Our ref: HA/2019/121217/01-L01
Your ref: EG/16/19/HH
Date: 09 April 2019

TWO STOREY EXTENSION

49 WARREN WAY BARNHAM PO22 0JX

Environment Agency position

Site & Block Plan

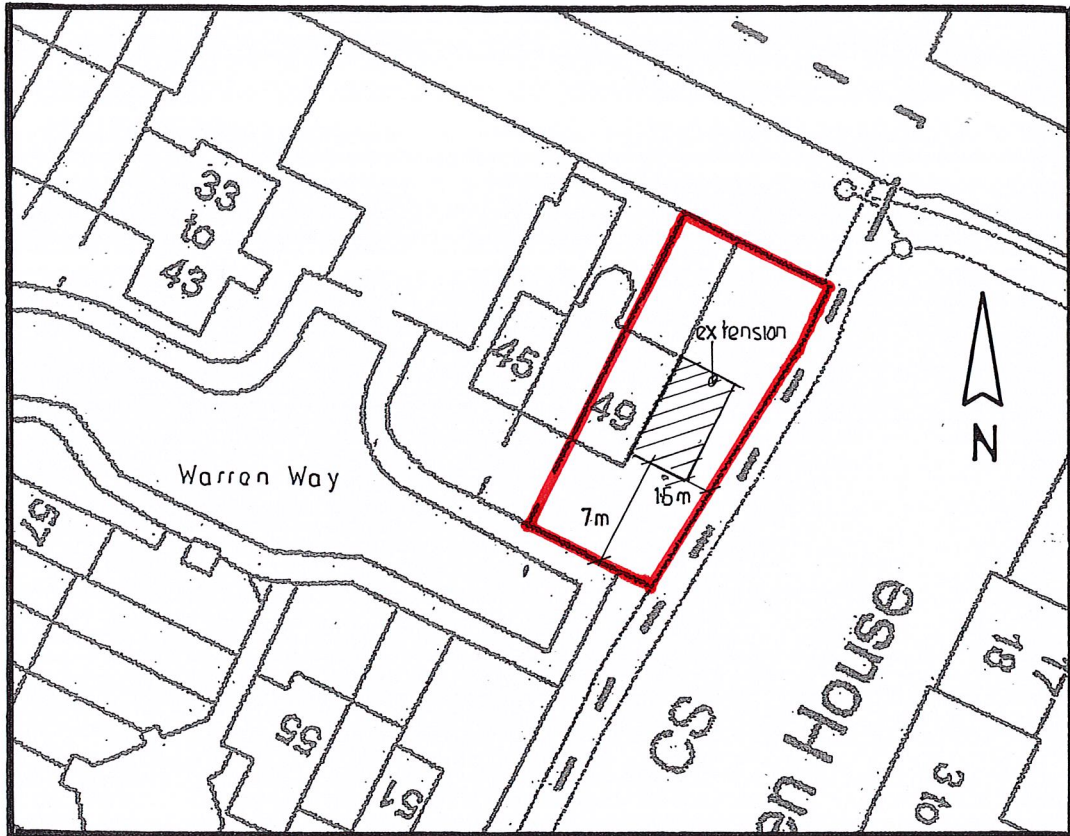
We object to this application as it is for a two story extension within flood zone 3 and is at risk of fluvial flooding. The extension is also proposed to be 1.6m from a main river.

- The proximity to the river could compromise the structural stability of both the bank and the proposed extension
